**KIRKLEES METROPOLITAN COUNCIL
INVESTMENT & REGENERATION SERVICE**

DELEGATED DECISION TO DETERMINE PLANNING APPLICATIONS

Reference No:	2023/62/91630/W
Site Address:	44, The Ghyll, Fixby, Huddersfield, HD2 2FE
Description:	Erection of two storey side extension
Recommending Officer:	Luke Walstow

HOUSEHOLDER DELEGATED REPORT

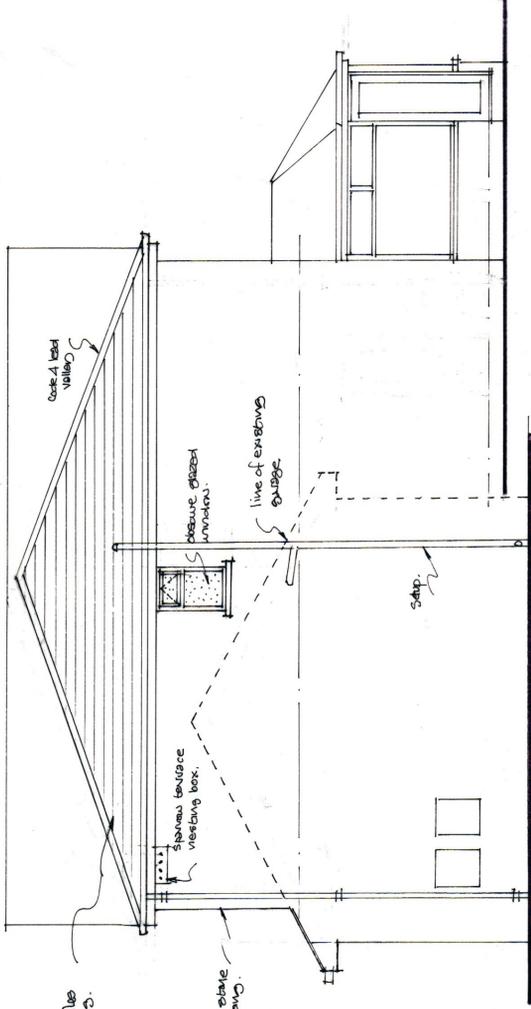
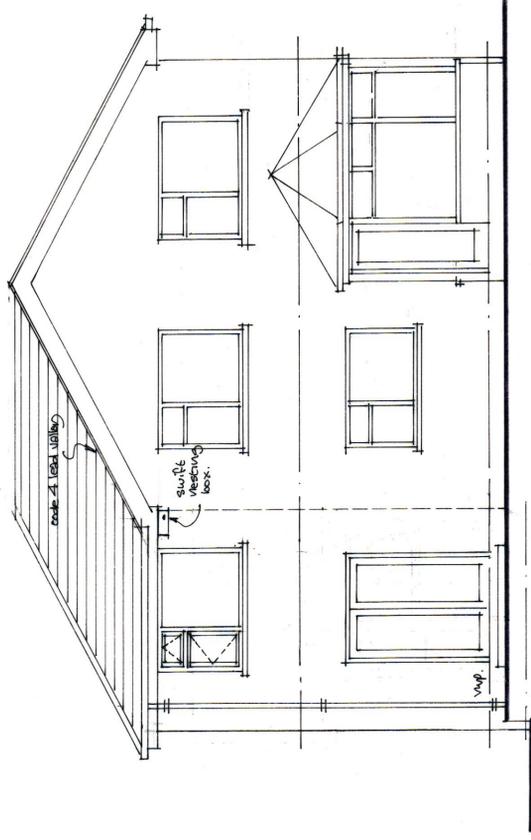
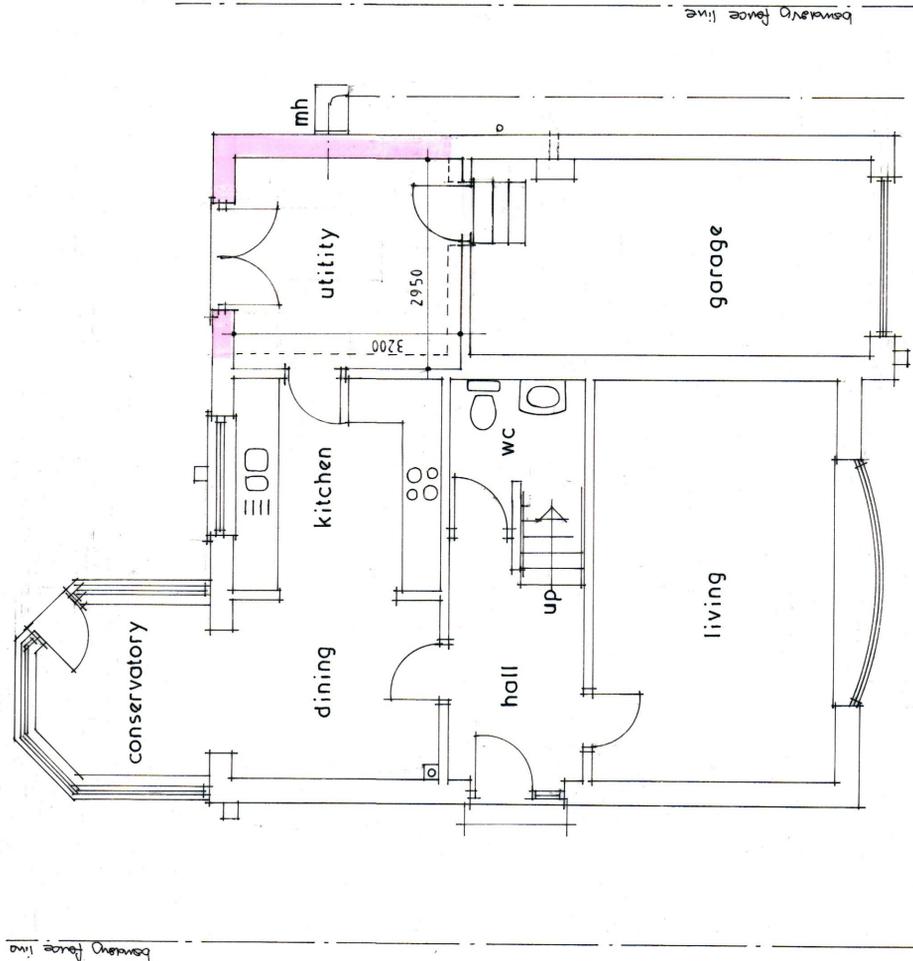
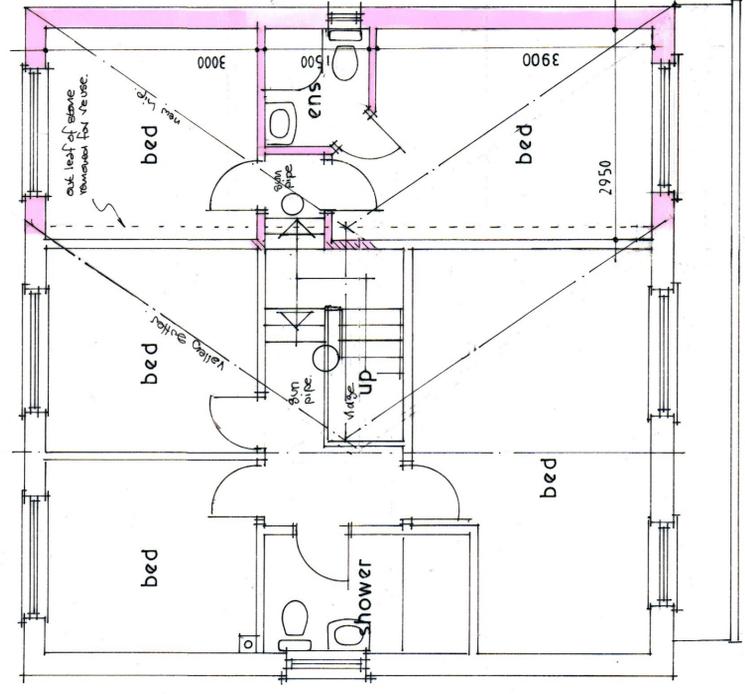
YES NO	/ SUMMARY
Negotiations/Amendments during course of application	Yes	Amendments were sought to lower the height of the extension roof to be below the existing roof and to be at least in line the front elevation from the existing front wall. The agent submitted a plan showing the requested amendments which were considered to be acceptable.

Two Storey Side Extensions Should:	<u>Yes - COMPLY</u>	<u>No - JUSTIFY</u>
Ideally be visually smaller in relation to the original house.	The proposed extension would be lower than the host dwelling after amendments were sought. It is visually smaller than the host dwelling structure, it is of good design with windows aligning with those in the original dwelling and materials matching existing materials. Officers can accept the extension based on these factors.	N/A
Have a roof design that follows the form of the existing roof.	The roofline would be constructed from the same materials used for the host dwelling and would have a similar	N/A

roof which merges into the existing roofline.	
Be set back at least 500mm from the front of the original house to provide a vertical break from the roof plane and for the lowering of the ridgeline from the original house	N/A	The first-floor element of the side extension would align with the existing first floor front wall after amendments were secured and would not leave a 0.5 metres set back. Whilst this does not align with the SPD, the dwelling is set back from the highway, and a site visit confirmed that although not set back, the extension would not create visual harm to both the original dwelling and the street-scene. The canopy roof at ground floor would follow through which provides a visually break between the ground and first floors.
Retain a gap of at least 1 metre to boundary walls to avoid a terracing effect and to retain rear access to gardens	A gap of 1 metre would be retained to the site boundary.	N/A

Height, scale and massing	• KDP 1 and 2 of the SPD • Policy LP24 Design (a), (c) and (d) of the KLP • Chapter 12 of the NPPF	The proposed height and scale of the proposed extension is mostly SPD compliant. The first-floor extension not being set back from the front elevation of the host dwelling is accepted here due to the host dwelling being set back from the highway, the character of the wider estate and the extension being of good design with aligning windows and similar construction materials being proposed.	✓

Relevant key design principle (KDP) of the SPD, Policy in the Kirklees Local Plan and the NPPF	Further comments	✓ / X / N/A
Impact on trees	• KDP 13 of the SPD • Policy LP24 Design (d) (i) (iv) Policy LP33 Trees • Chapter 12 of the NPPF	N/A	✓
Impact on ecology	• KDP 12 of the SPD • Policy LP30 • Chapter 15 of the NPPF	A species enhancement has been provided stating a house sparrow nesting terrace would be installed under the eaves on the East elevation of the new extension with	✓

alongside a swift nesting box installed under the eaves on the North Elevation. This will be controlled by condition.	
Carbon Budget / Climate change statement	• KDP 8, 9, 10 & 11 of the SPD • Policy LP51 • Chapter 14 of the NPPF	Small scale domestic development to an existing dwelling. As such, no special measures required in terms of the planning application with regards to carbon emissions. A Climate Change Statement has been submitted with this application.	✓
Drainage and Flood Risk	• KDP 14 of the SPD • Policy LP24 (d) (vii), LP27 and LP34 of the KLP	The rear garden and landscaping would be retained to allow for run-off. The site is not located within an identified Flood Risk Zone 2 or 3 area.	✓

4. The bird box and terrace species enhancements indicated on plan no. 2A and specified within the species enhancement statement shall be installed during the period of construction and before the extension is first occupied. Thereafter, the bird box and terrace shall be retained.
